NORWICH TO TILBURY

EN020027

Comments on Submissions received at Deadline 6

Suffolk County Council

Drawing Number:
10059280-ARC-EHR-ZZ-DR-ZZ-00432
Revision:
C

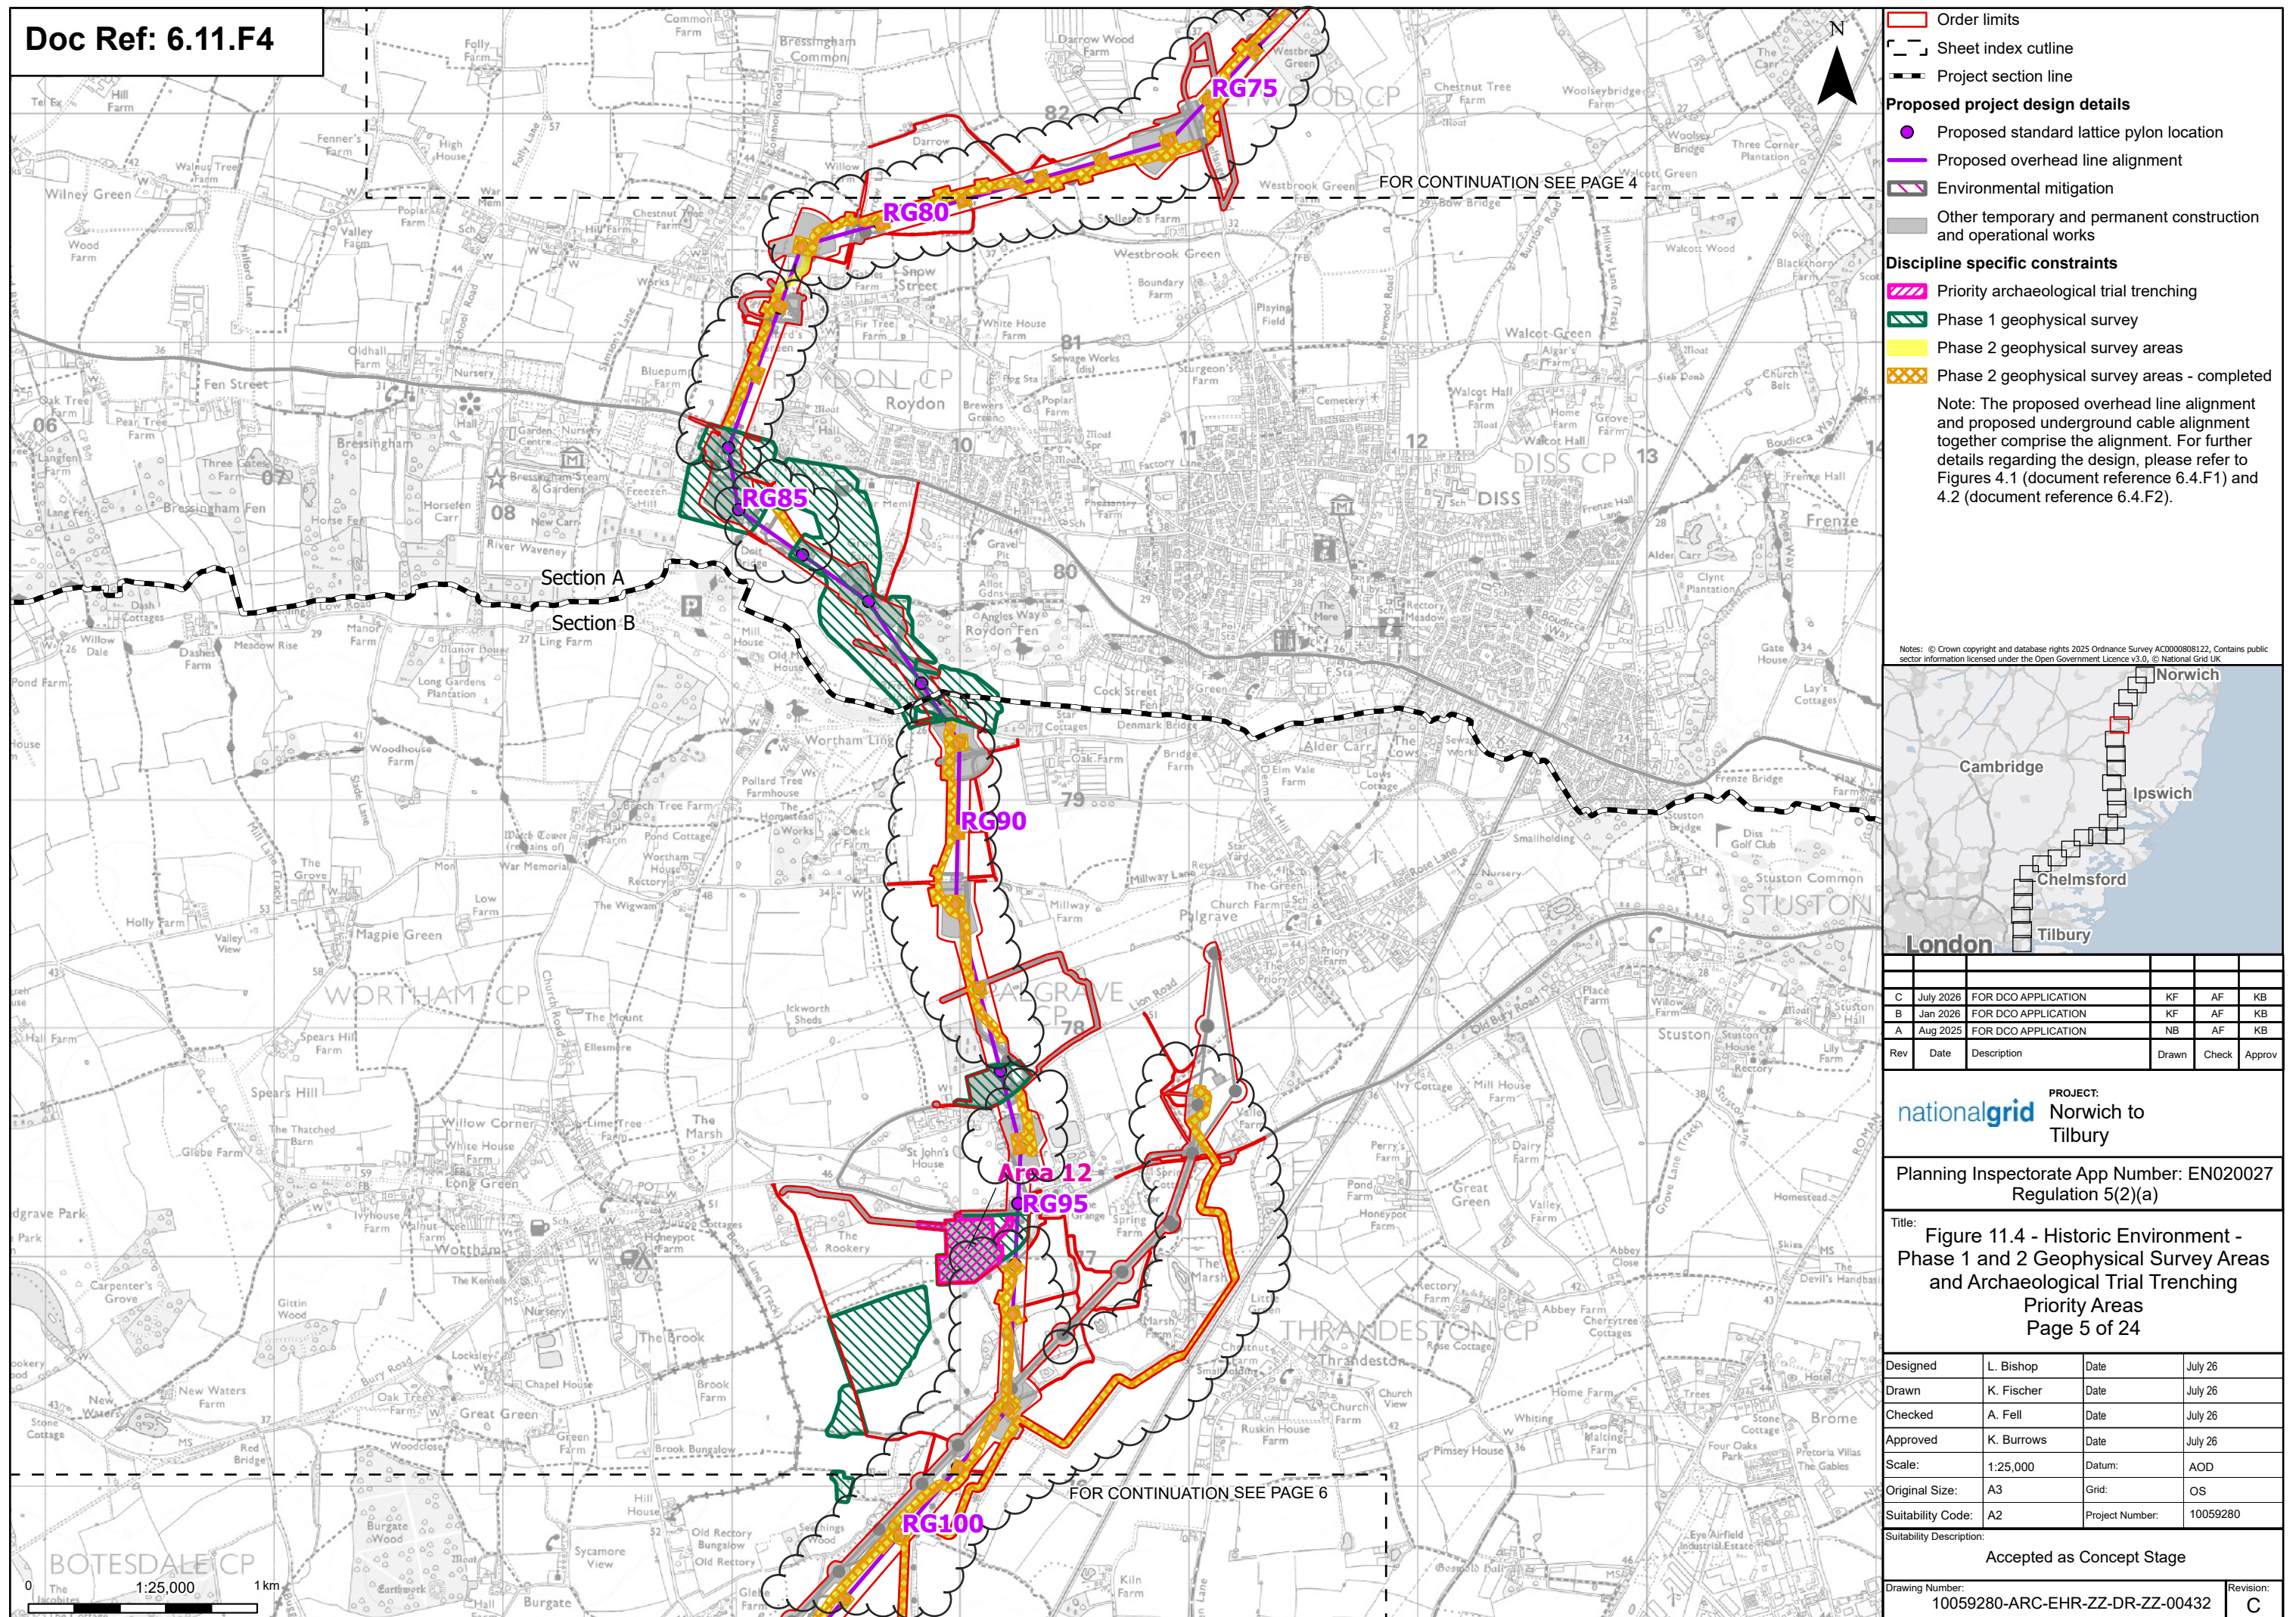
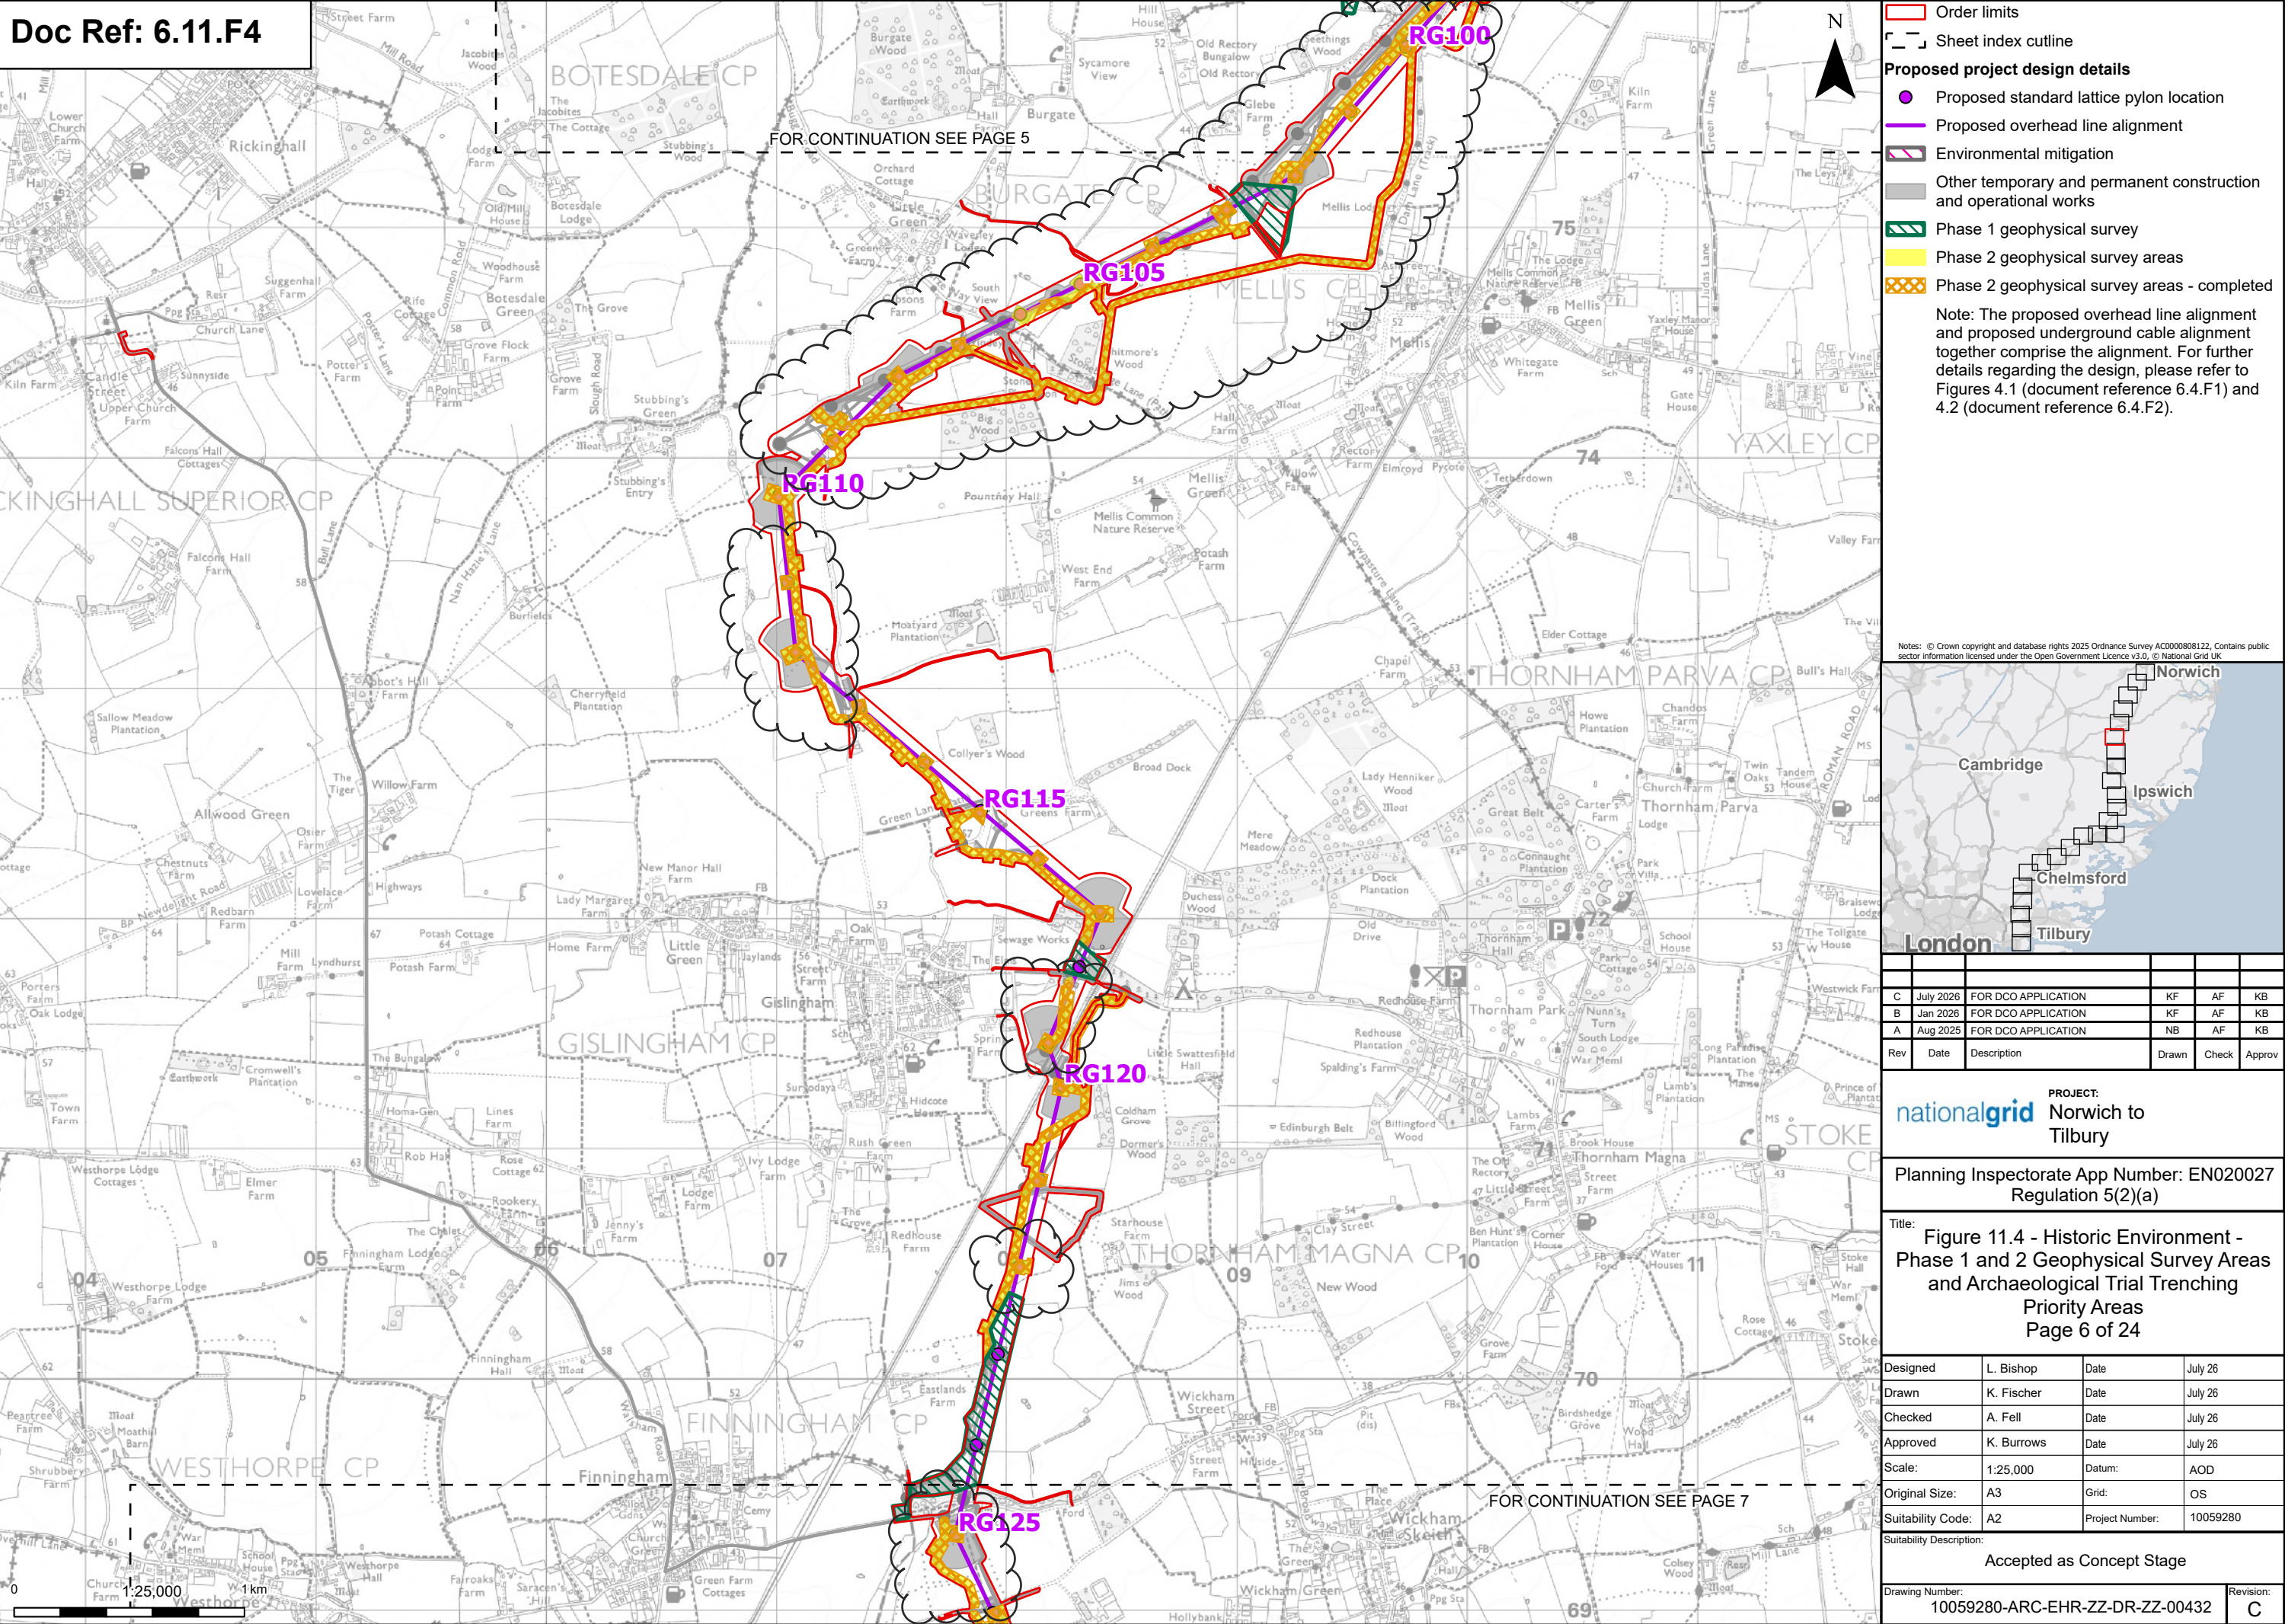
Table 4: 6.11.F4 (C) Phase 1 and 2 Geophysical Survey Areas and Archaeological Trial Trenching Priority Areas [REP6-069]			
Table Item	Service Area and/or Topic	Referenced Paragraph or Item	SCC's Comments

4.1	Archaeology	General Comment	This plan identifies the areas that have undergone priority evaluation, including priority geophysical survey and trial trenching. It also shows those areas where Phase 2 geophysical survey has been undertaken. SCCAS welcomes the submission of this plan as part of the Examination. Document 6.11.A8 Environmental Statement Appendix 11.8 – Phase 2 Geophysical Survey [REP6-065] states that approximately 86% of the Phase 2 area has been subject to geophysical survey. Figures in 6.11.F4 Phase 1 and 2 Geophysical Survey Areas and Archaeological Trial Trenching Priority Areas [REP6-069] indicate the unsurveyed areas, the applicant should state when these remaining areas will be surveyed or, where survey is not possible, how they will be archaeologically evaluated.
